# CITY OF ALBUQUERQUE

June 19, 2017

**RE: Sunset Farms / Puesta Del Sol  
336 Luis Sanchez Place SW  
Engineer's Certification Dated - None  
Hydrology File: K12D025**

Based upon the information provided in your submittal received 6/14/2017, the Grading Plan **is not** approved for Building Pad Certification for Lot 47-P1. The following comments need to be addressed for approval of the above referenced project:

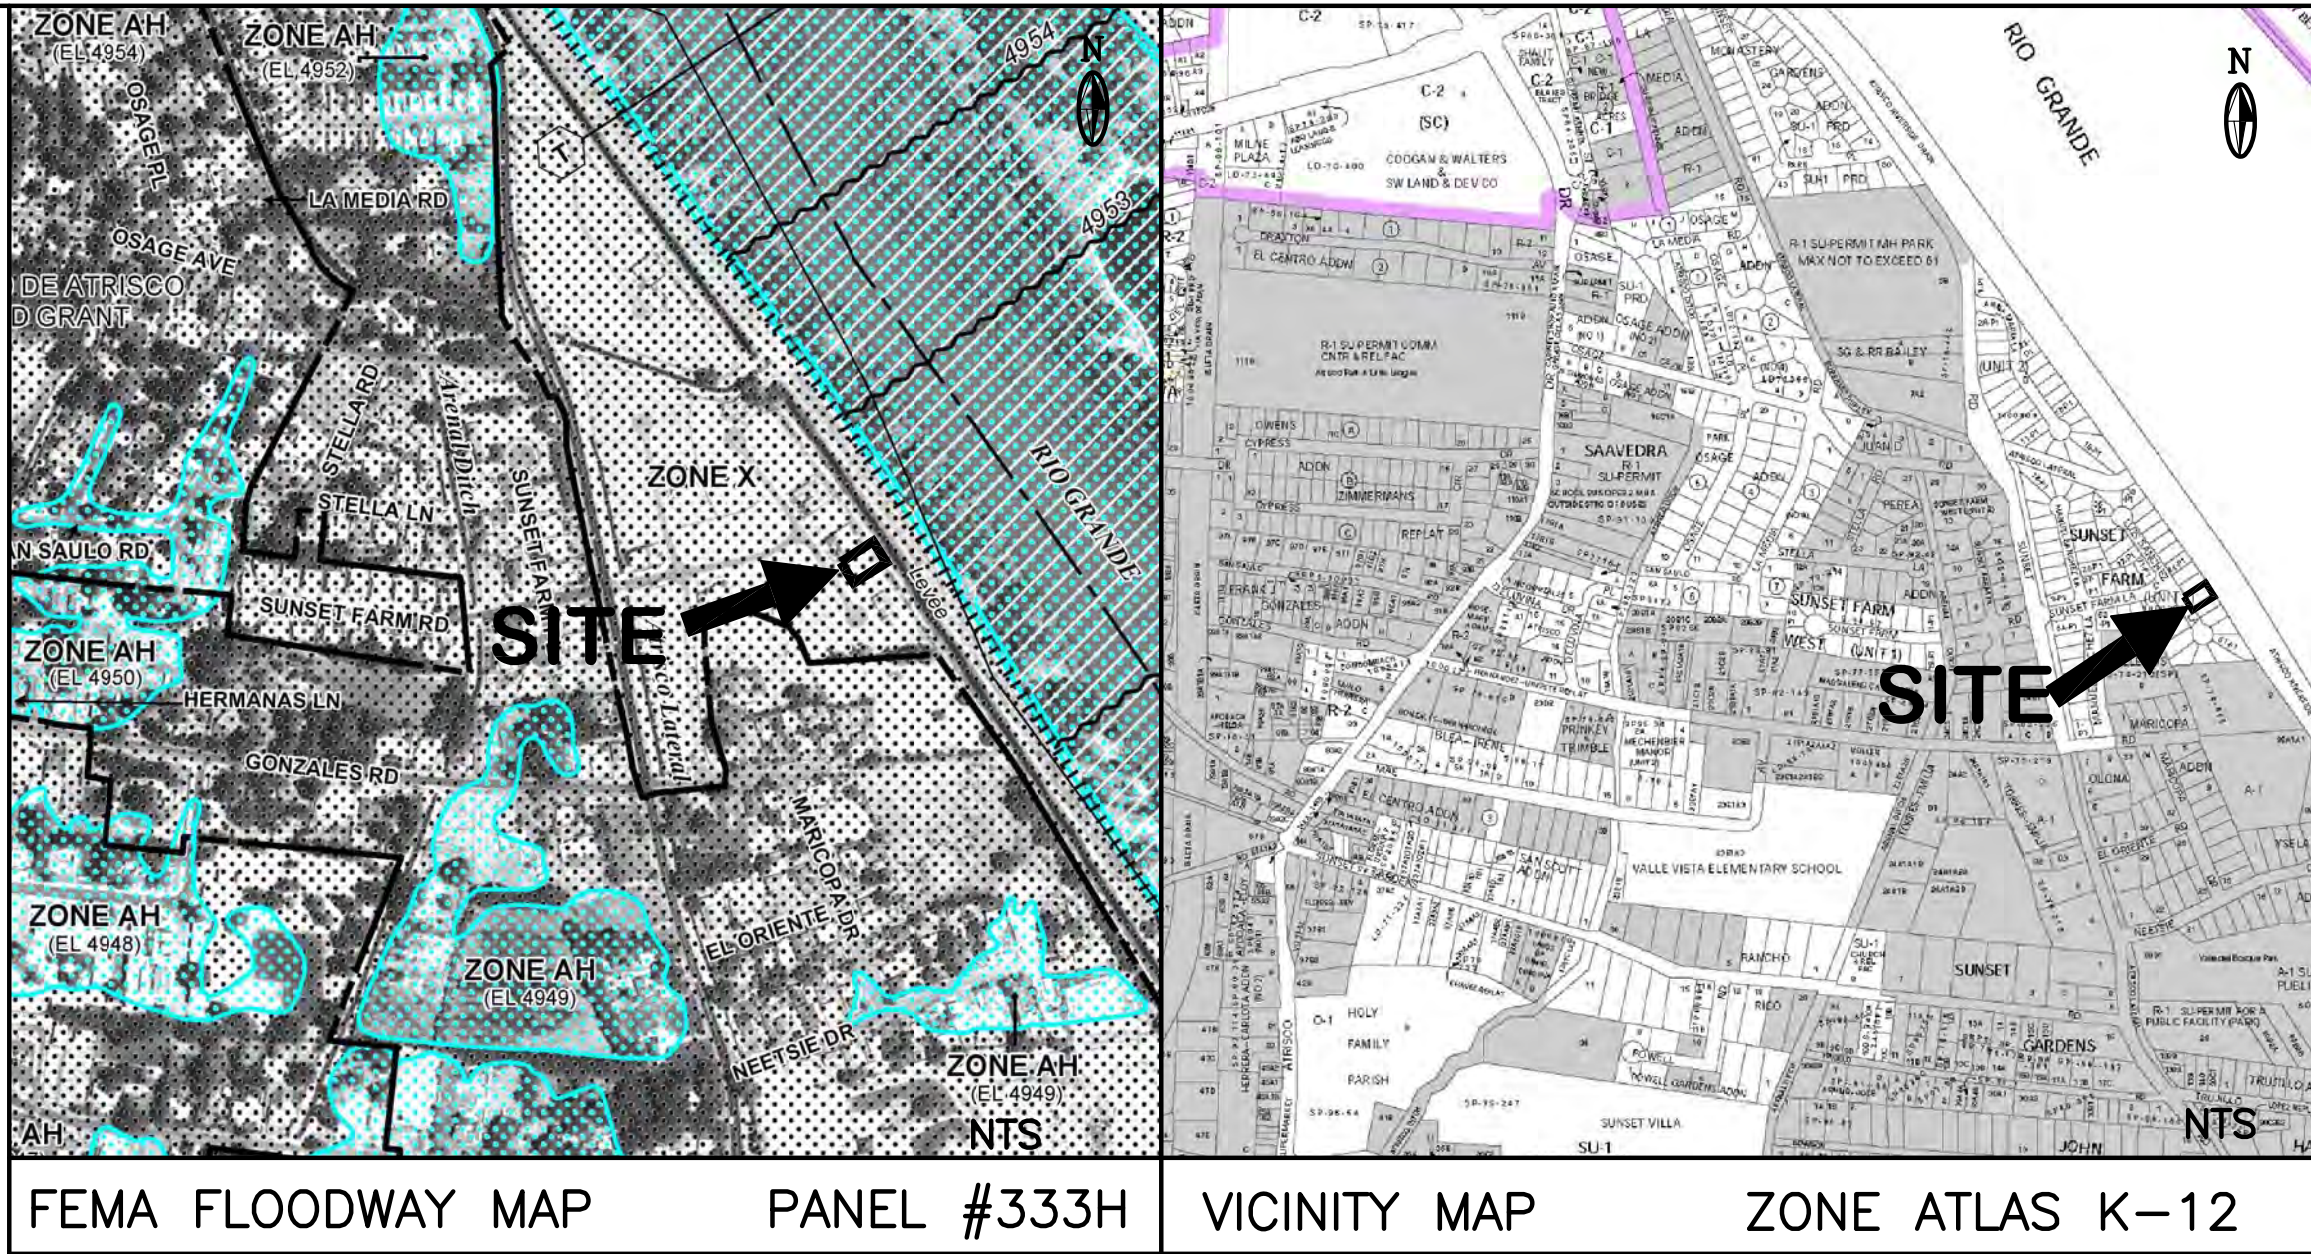
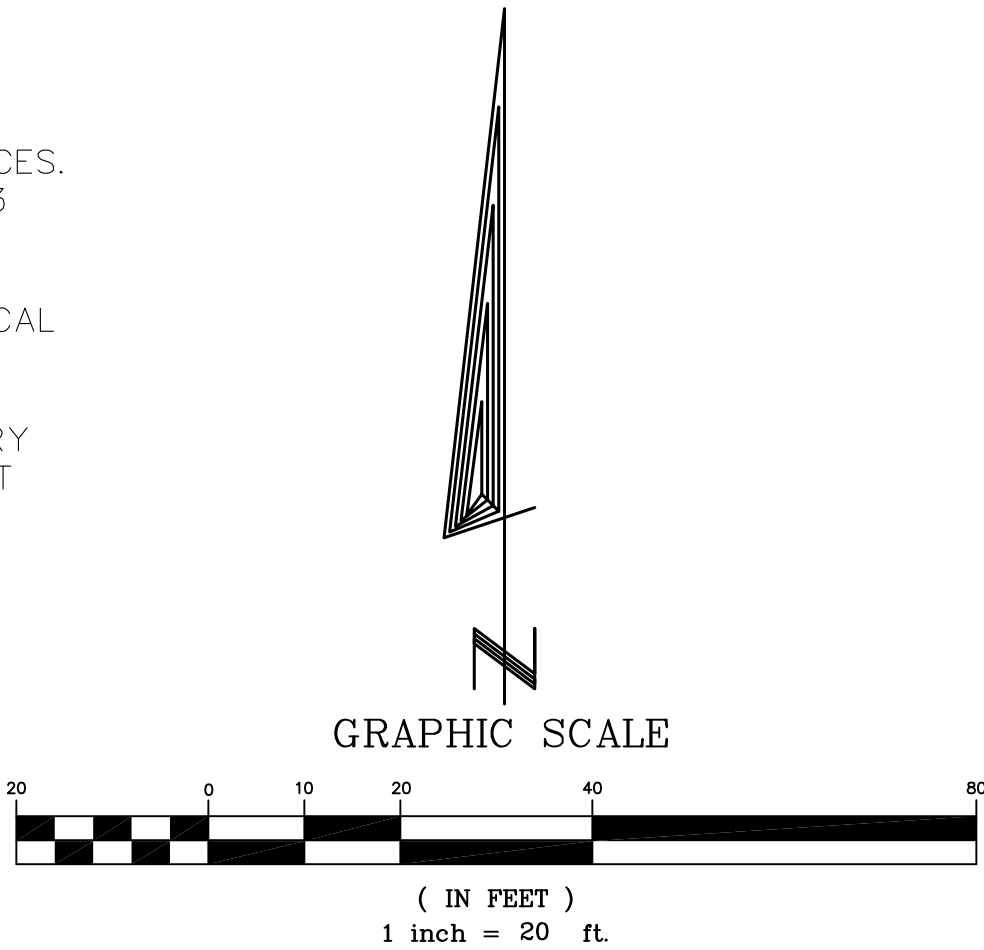
1. Please place the pad elevations from the surveyor's drawing on the approved grading plan.
2. Jackie McDowell, your civil engineer needs to provide the flowing on the approved grading plan with the pad elevations and needs to sign and seal the plan.

3. Please take photo or photos of the lot showing the graded pad of the site and email them back to me. This will speed up the process so I do not have to do a site visit.
